Arun District Council
Arun Civic Centre
Maltravers Road
Littlehampton
West Sussex BN17 5LF
Planning & Building Control General Enquiries
Tel: (01903) 737756 Fax: (01903) 730442
Dx: 57406 Littlehampton
Minicom: 01903 732765
e-mail: planning@arun.gov.uk
website: www.arun.gov.uk/planning

Application No: FG/57/22/PL
Site Address: 12 Little Paddocks Ferring BN12 5NJ
Description of works: Demolition and erection of 1 No new dwelling. This application is in CIL Zone 4 and is CIL Liable as new dwelling.

Thank you for your internet representation made on 12th May 2022 which has been recorded as an objection with the comments as follows:

DRAWING No.
**Drawing 1
Existing & Proposed
Floor Plans & Elevations**

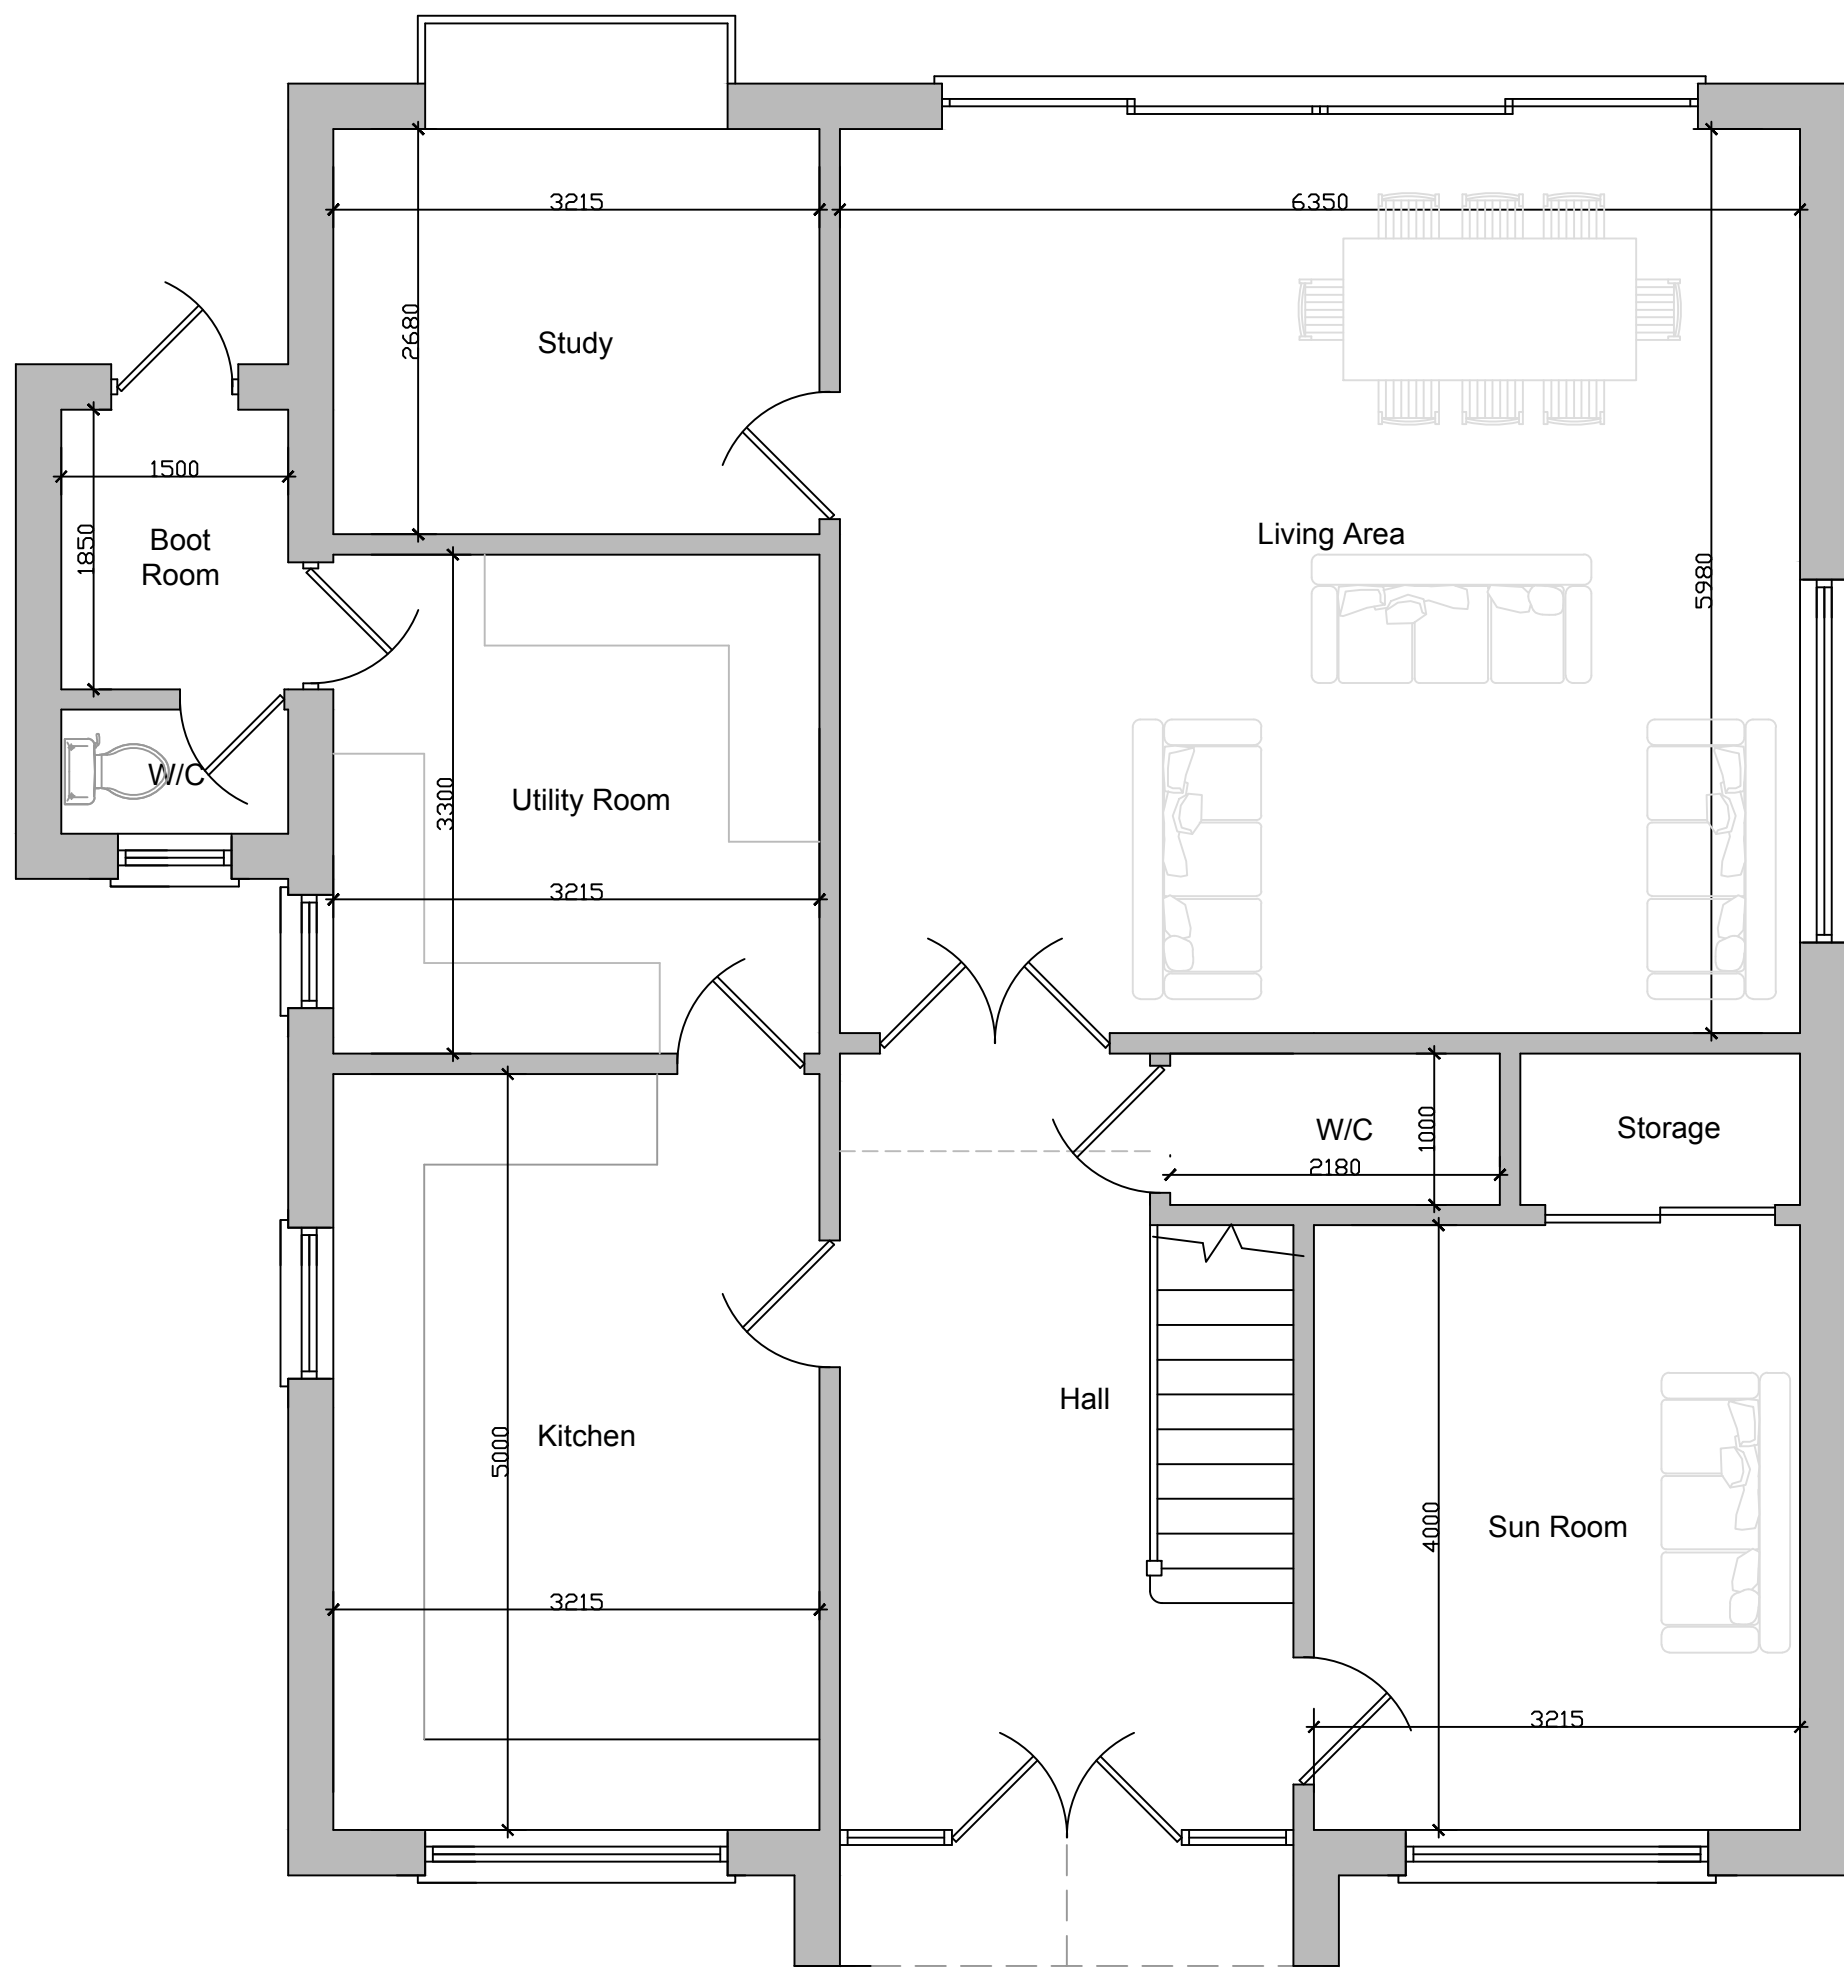
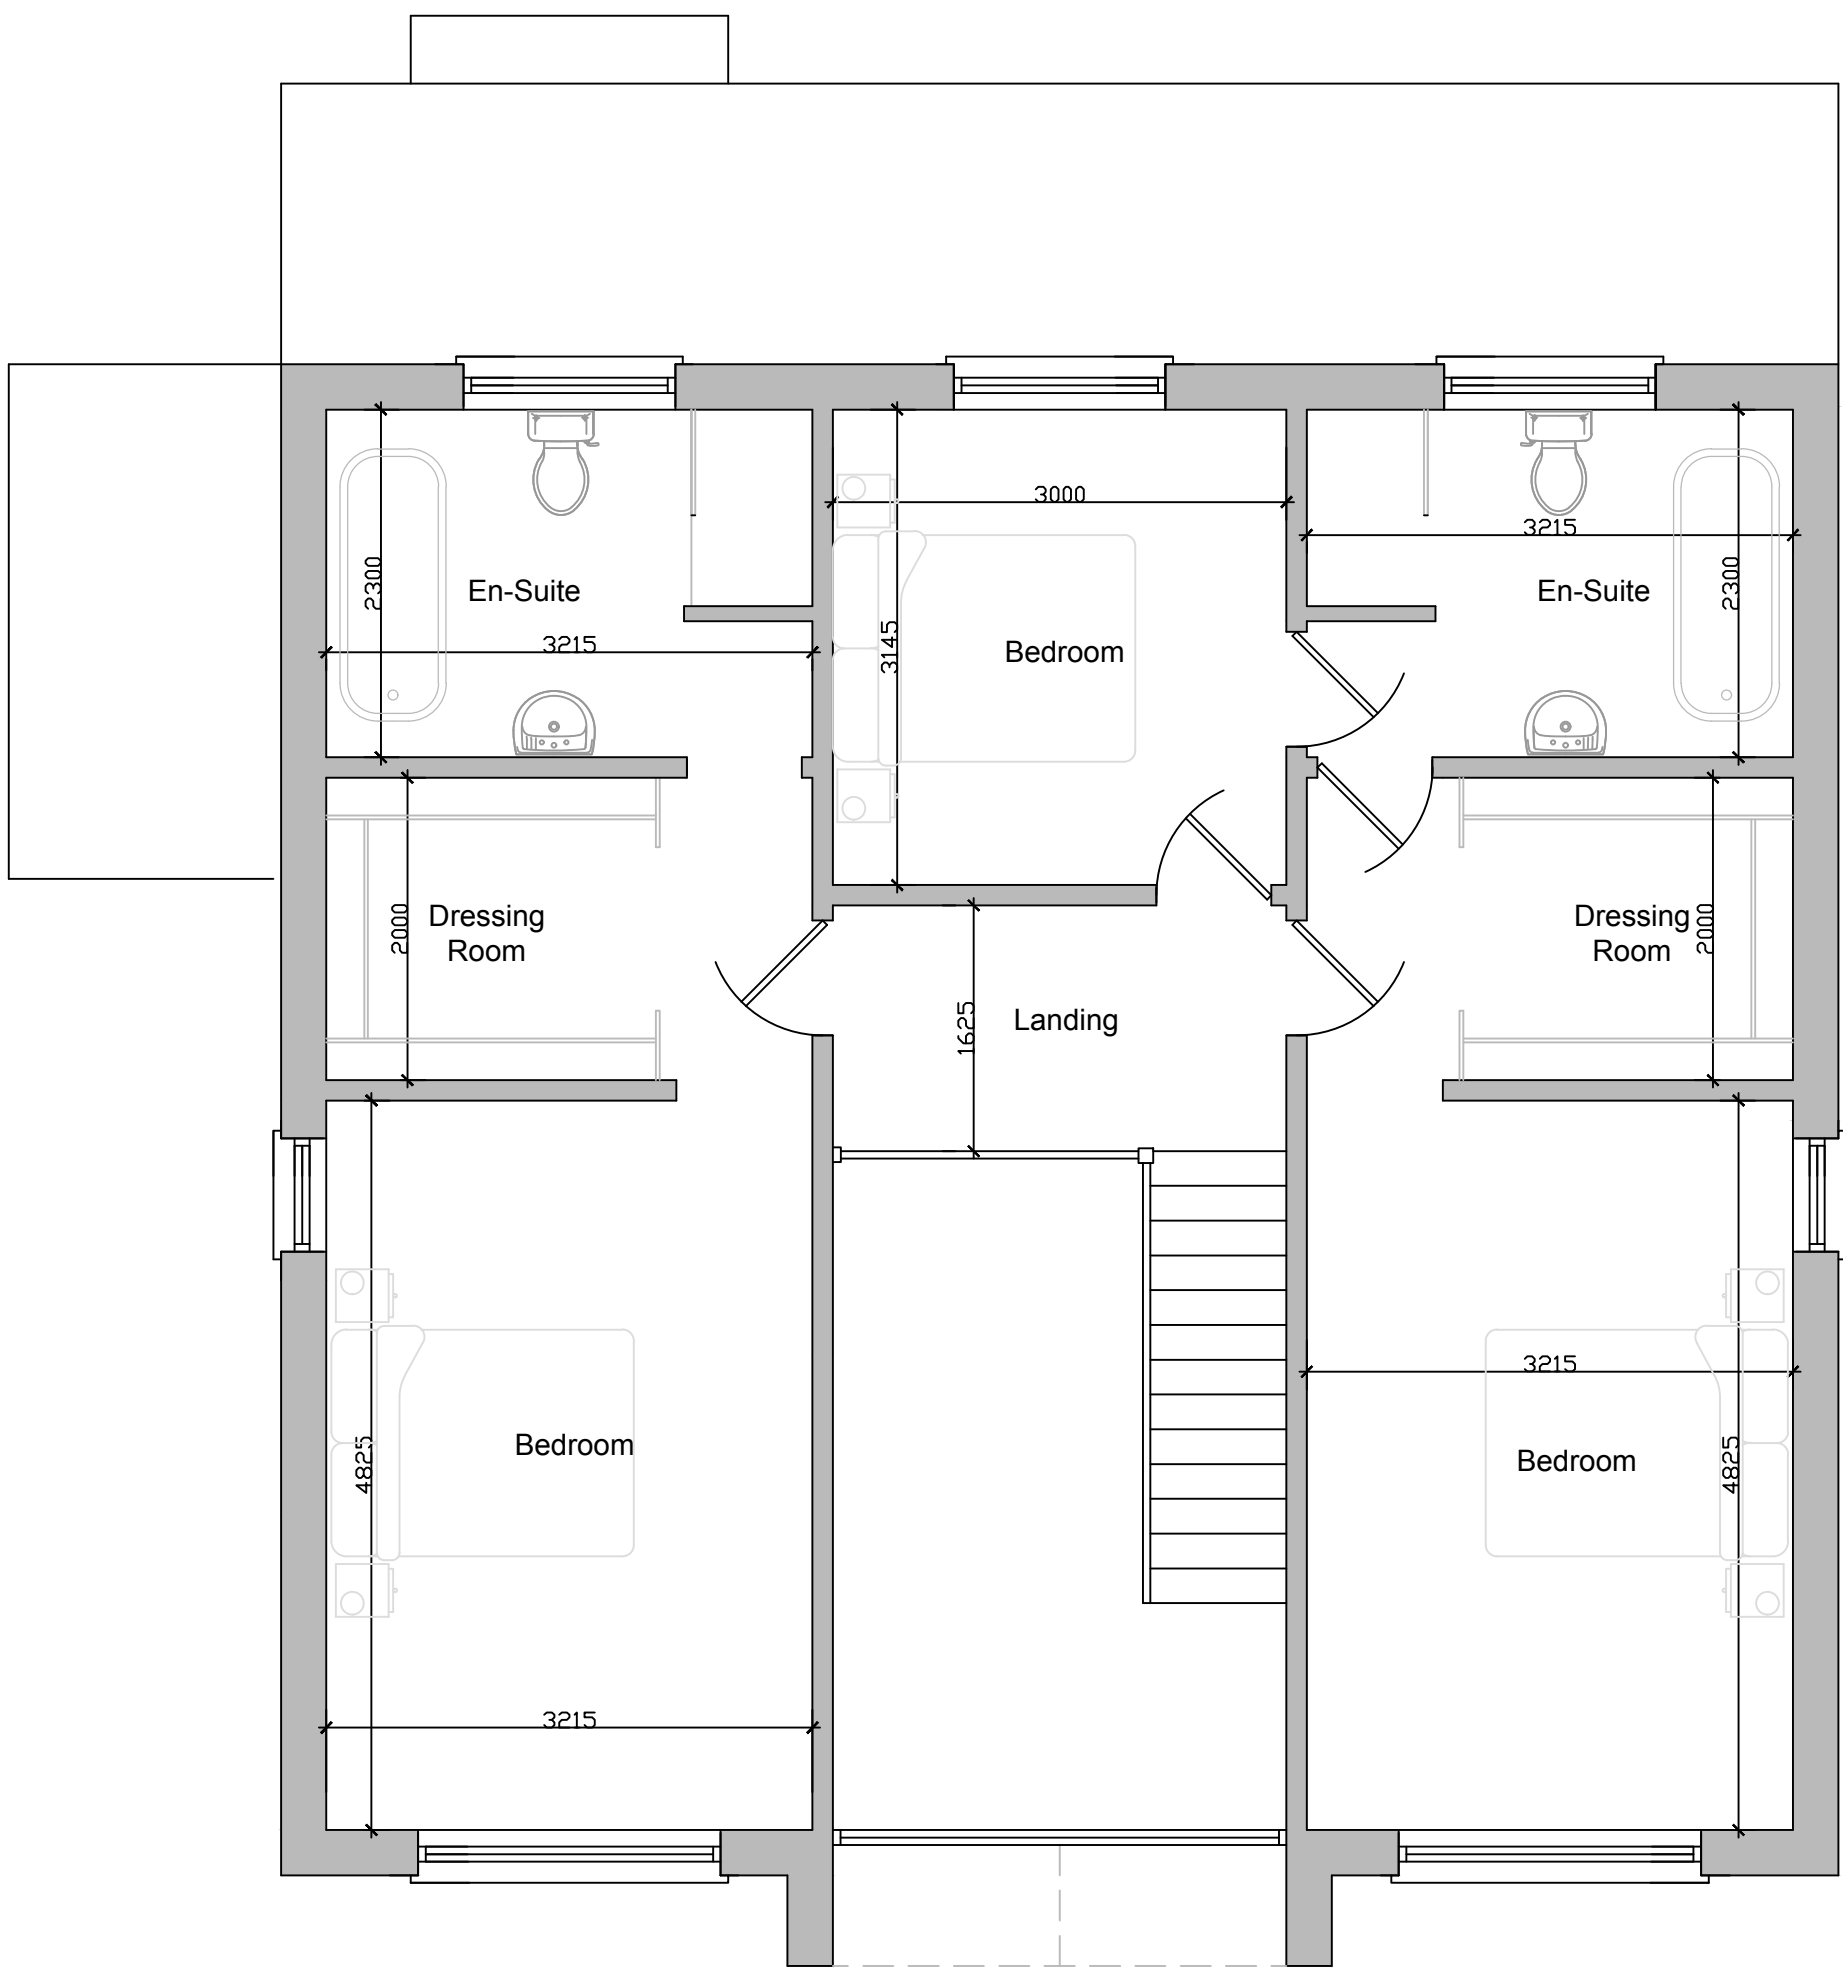
The scale and contemporary external appearance of the proposed development has clearly not been designed with any thought to blend with the existing character bungalows in the incomparable green space of the northern part of Little Paddocks. Whilst the ground floor footprint may approximate to the existing footprint (if you include the car port on the east side), the first floor is dramatically larger than the first floor of the existing dormer bungalow.

Furthermore, the plans portray a 3-bedroom detached house. However, the floor plan of the first floor shows two very large master bedrooms, a good-sized third bedroom and a further two not insignificant dressing rooms. So, the proposed build is the equivalent of a four or even five-bedroom property. It is therefore clearly not a like-for-like replacement property. Other bungalows in Little Paddocks have been tastefully refurbished whilst retaining their original external character.
